August 27, 2020

Subject: Zipperer Preliminary Shore Plat (SP-20-00005) – Transmittal of Comments and Request for Additional Information

ZIPPERER SHORT PLAT, SP-20-XXXX

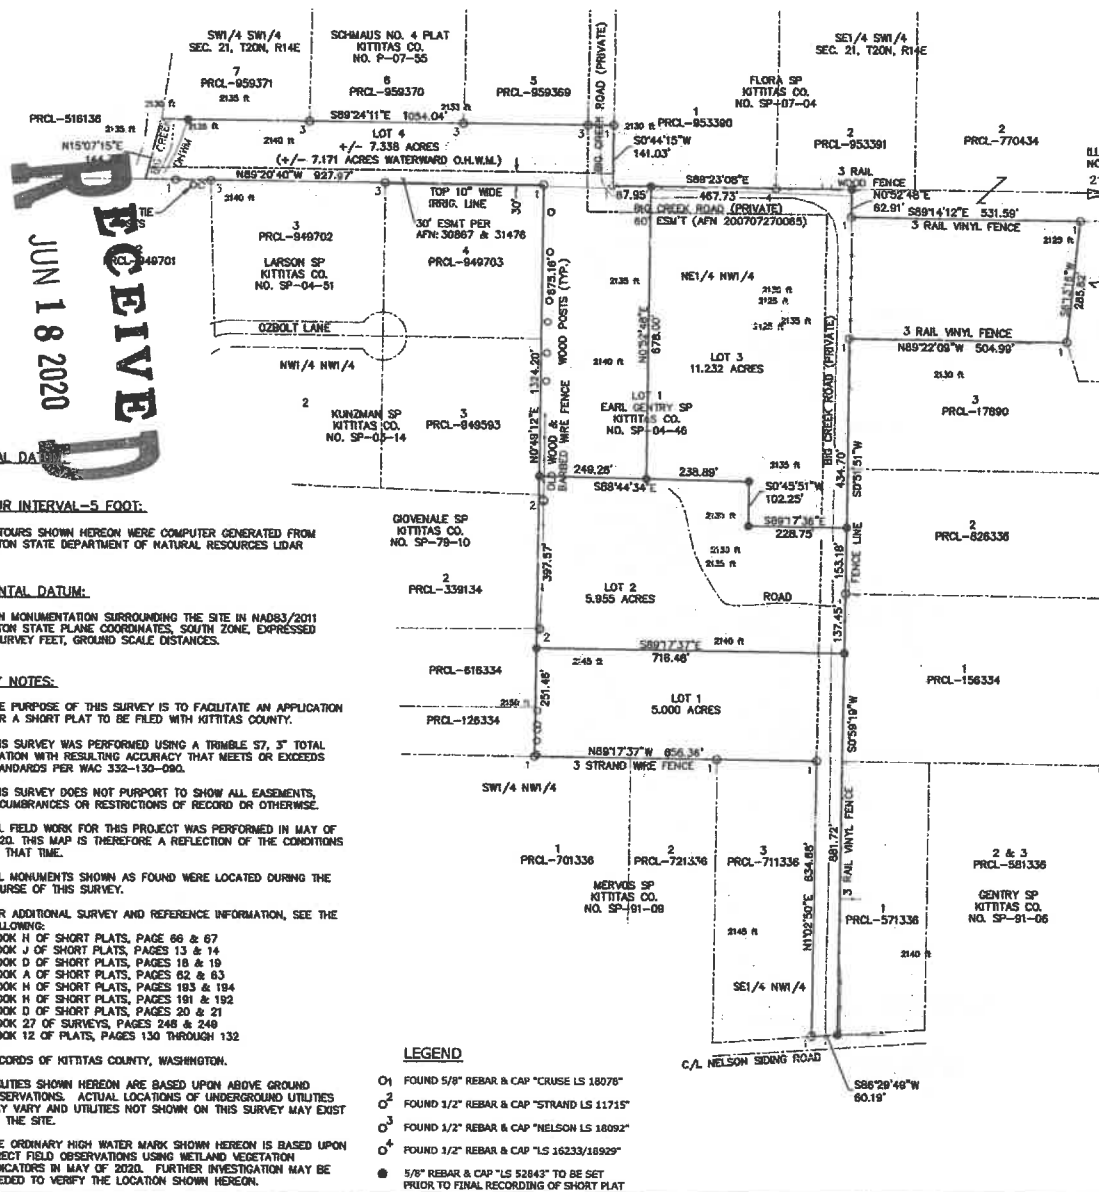
1. Pursuant to the Kittitas County Public Health comments (enclosed), please provide the additional information requested:
 - a. Clarification on the on-site sewage disposal system plan.
